From: [REDACTED]
Sent: 25 September 2025 15:58
To: Planning
Subject: Re: 3/2025/0651 comments

Apologies, yes the officer is quite right the attached comments are in respect of application:
3/2025/0654 Crane Wood Barn Cowark.

To: Planning <planning@ribblevalley.gov.uk>
Subject: 3/2025/0651 comments

SIDE / EAST ELEVATION

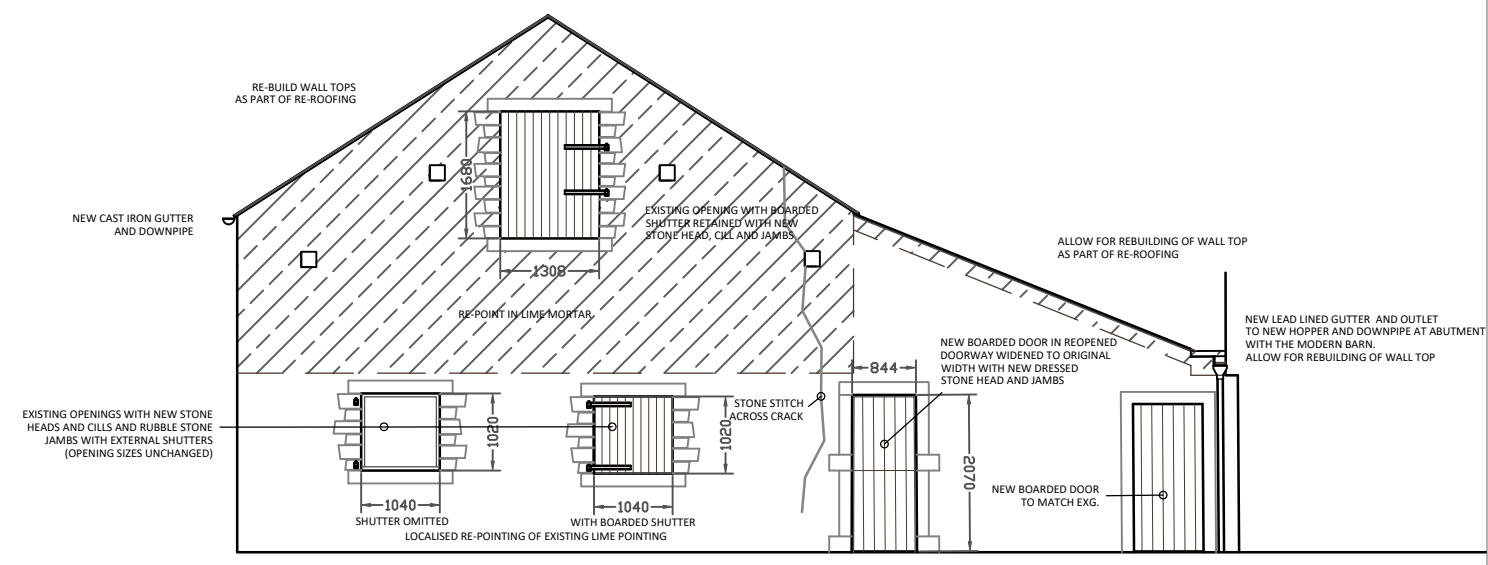
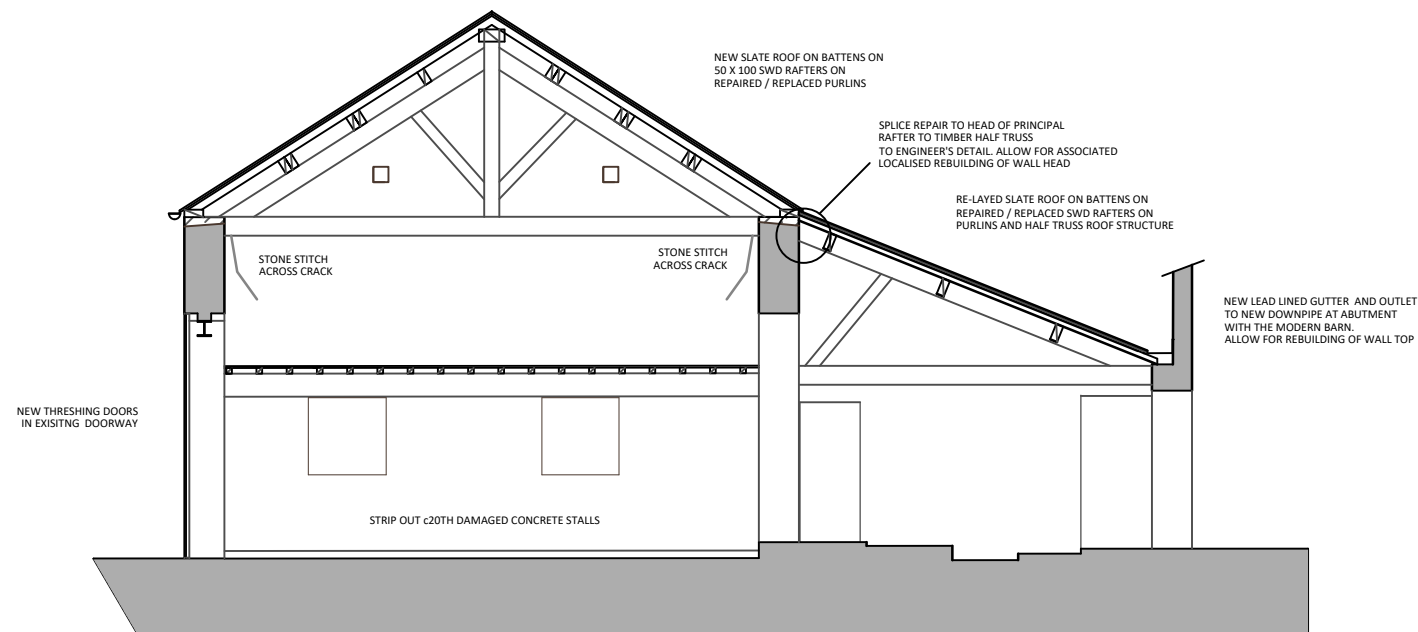
[REDACTED] noted many times, and the previous owner also pointed out to [REDACTED] that the barn owls entered this barn through the Eastern elevation.

The report from Bowland Ecology mentions fixing an owl box to the Southern End of the barn; however, it would seem a reasonable request to also fix an additional one to the Eastern side. The owls previously resided within the attic space of the barn. Are we correct in thinking that the new owl boxes will also be housed within the barn attic space?
